Pagham Beach (Holdings) Ltd

5th March 2020

Application ref: P/117/19/PL

36 East Front Road, Pagham – proposed replacement dwelling

PROPOSED STREET
SCENE & BEACH
SCENE

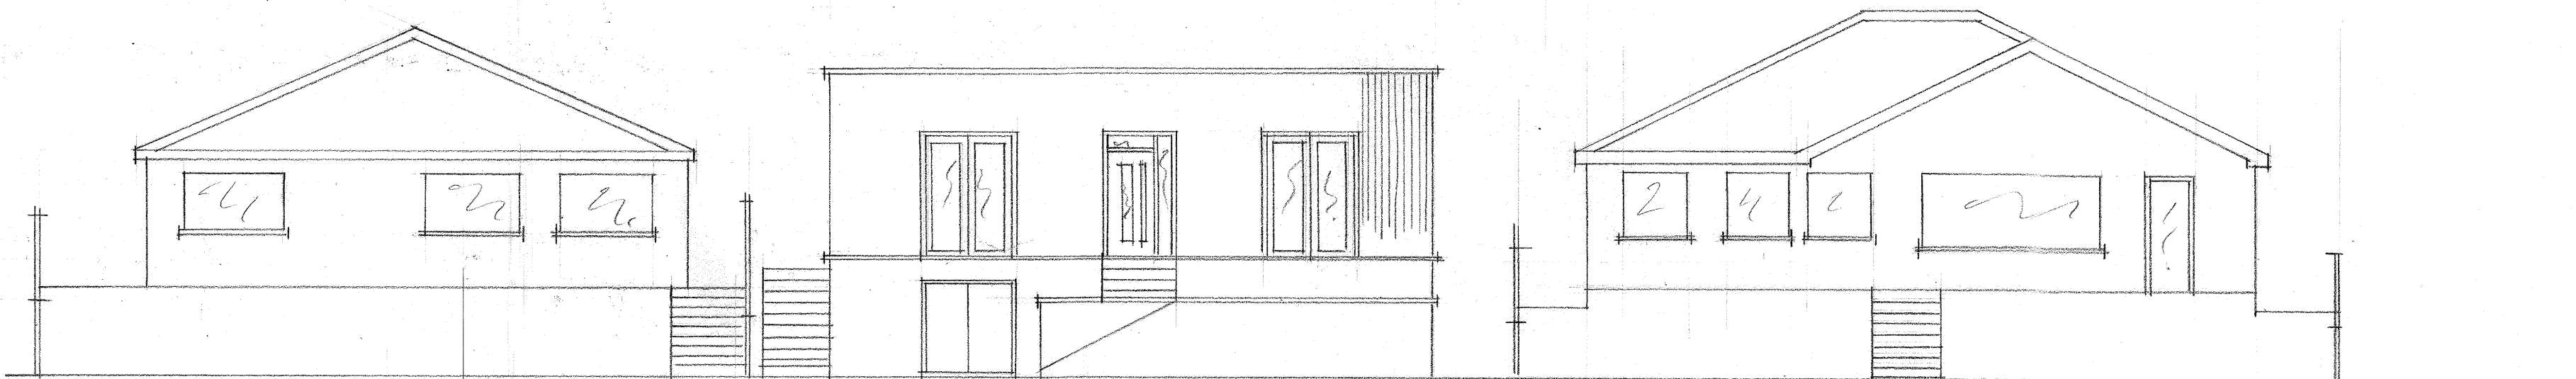
I also now note that EA has recommended that FFL within the building should be constructed at no lower than 5.53 AOD, which is the same figure that is defined within the Applicant's Flood Risk Assessment. However, there is no reference within the Applicant's Design & Access Statement or within the Beach Scene Elevation and Street Scene Elevation Drawings to confirm that the proposed bungalow has been drawn to reflect the FFL. In the circumstances I would urge the District Council to request this confirmation from the Applicant or his agent.

AGENT: CROSS DESIGN & BUILD LTD. 58 EAST FRONT ROAD PAGHAM WEST SUSSEX PO21 4ST. 07973 64404	CLIENT MR C MASSEY 36 EAST FRONT ROAD PAGHAM WEST SUSSEX PO21 4ST.	PROPOSED NEW HOME PROPOSED GROUND FLOOR PLAN SCALE 1:50 DRG NO 17/1/1.
--	---	---

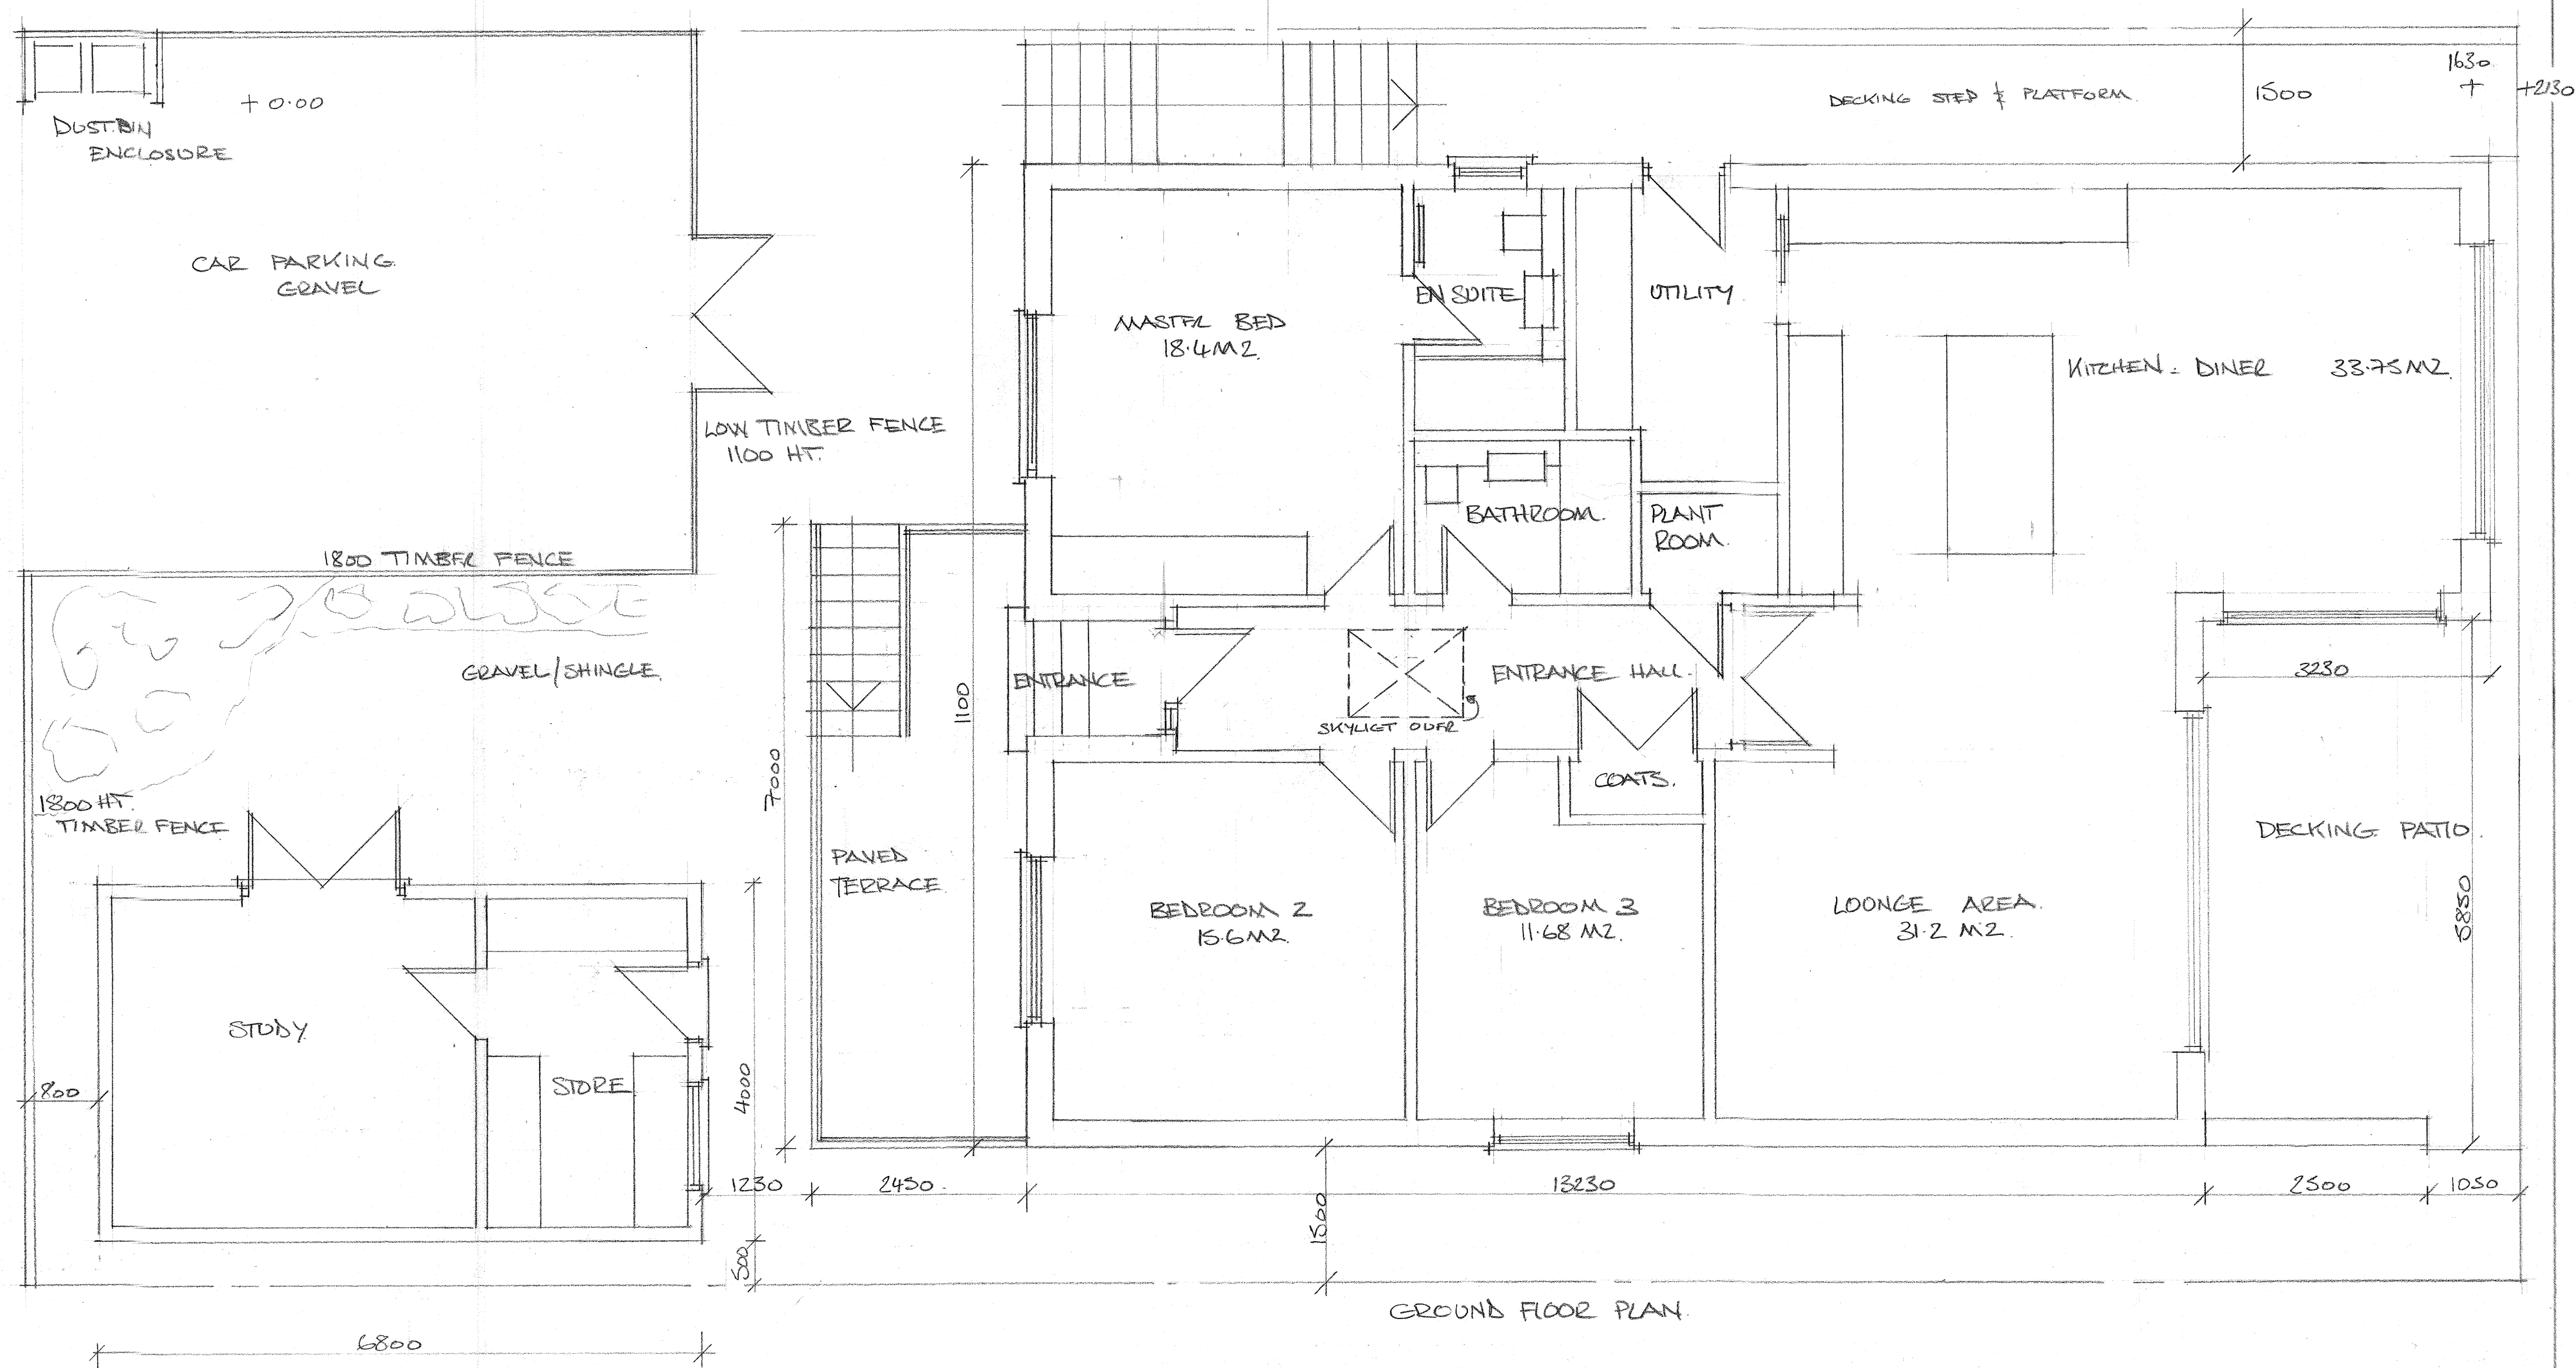
In my previous letter I also raised the question of the on-site parking which must be provided for this development. The number of car parking spaces are not defined and the Applicant should be required to confirm that there is adequate on-site turning space within the site for vehicles. Given the nature and width of East front Road at this position, vehicles should not be allowed to reverse into the road but must be able to leave the site in a forward direction, for reasons for highway safety. I see no evidence on the District Council's Application file that the Planning Authority has sought this information.
